Subject: Response to 20/01830/F

Please see below the response from Ambrosden Parish Council to application 20/01830/F:

Drawing 3: Proposed Site GA Plan (Drawing ref. WIE11386-145-03-001)

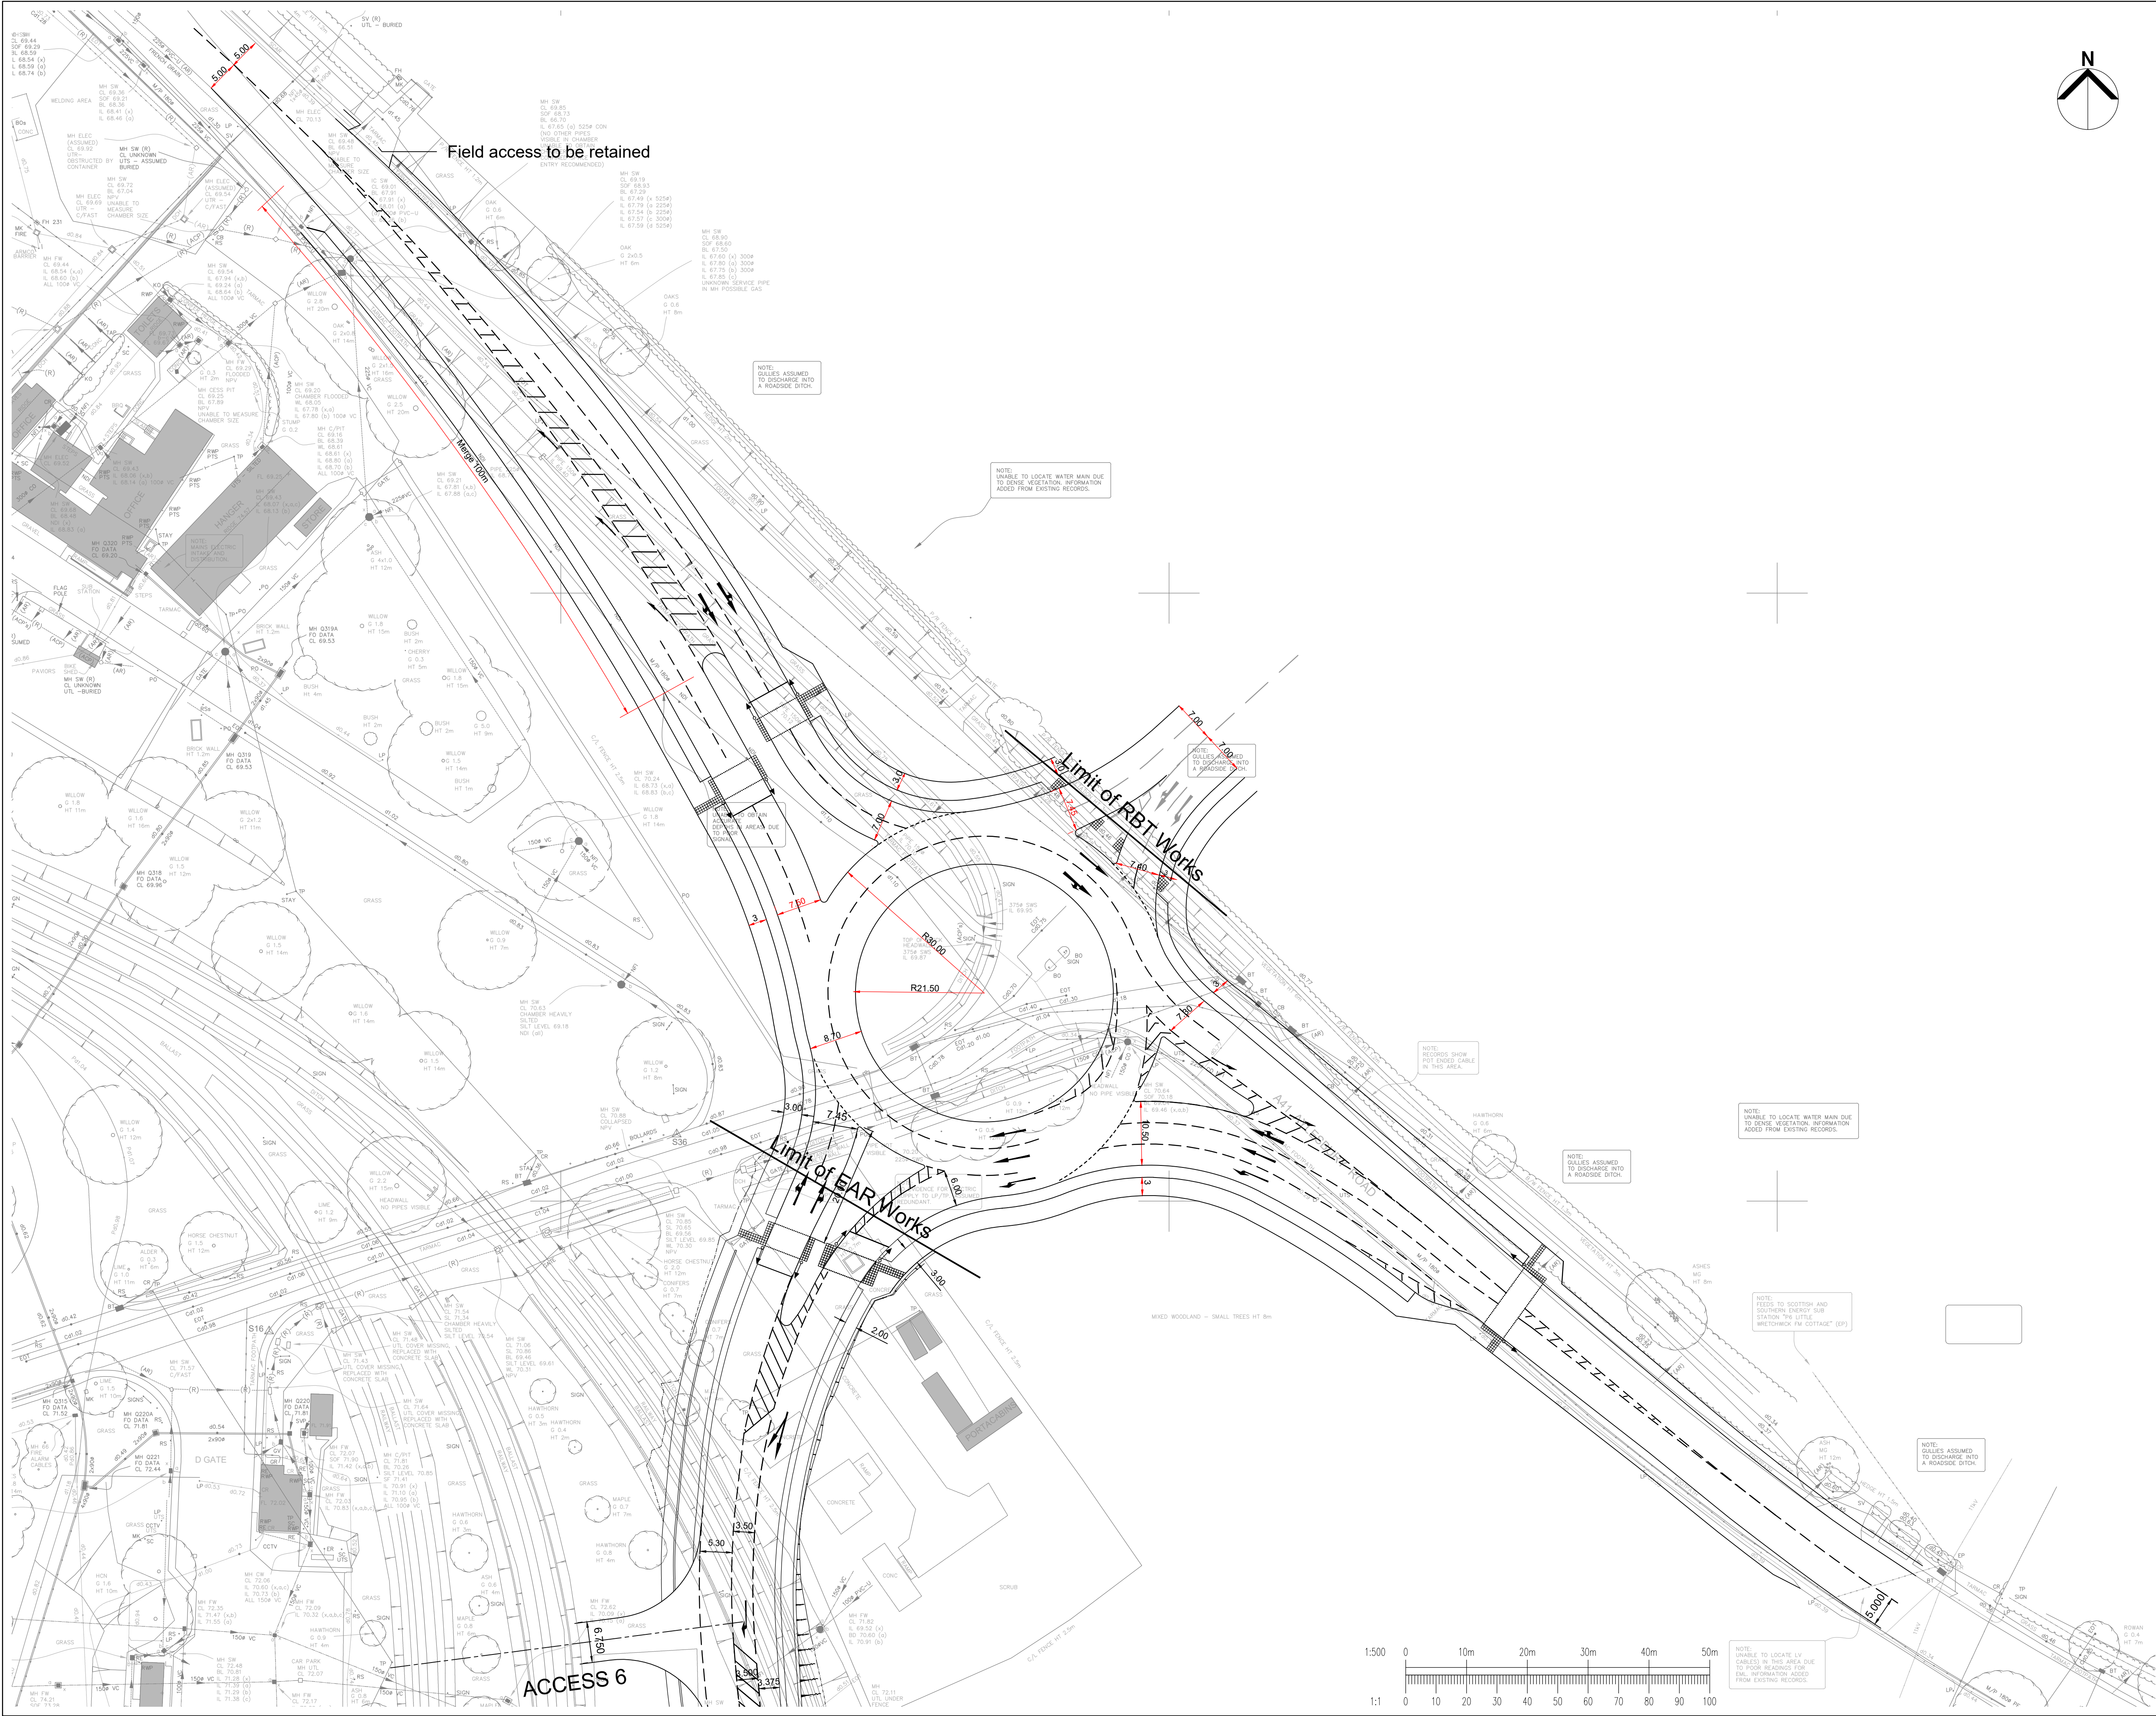
Request the cycle way is widened to 3m wide all the way to Ploughley Road, as a sudden narrowing would risk cyclists/pedestrians going into the road
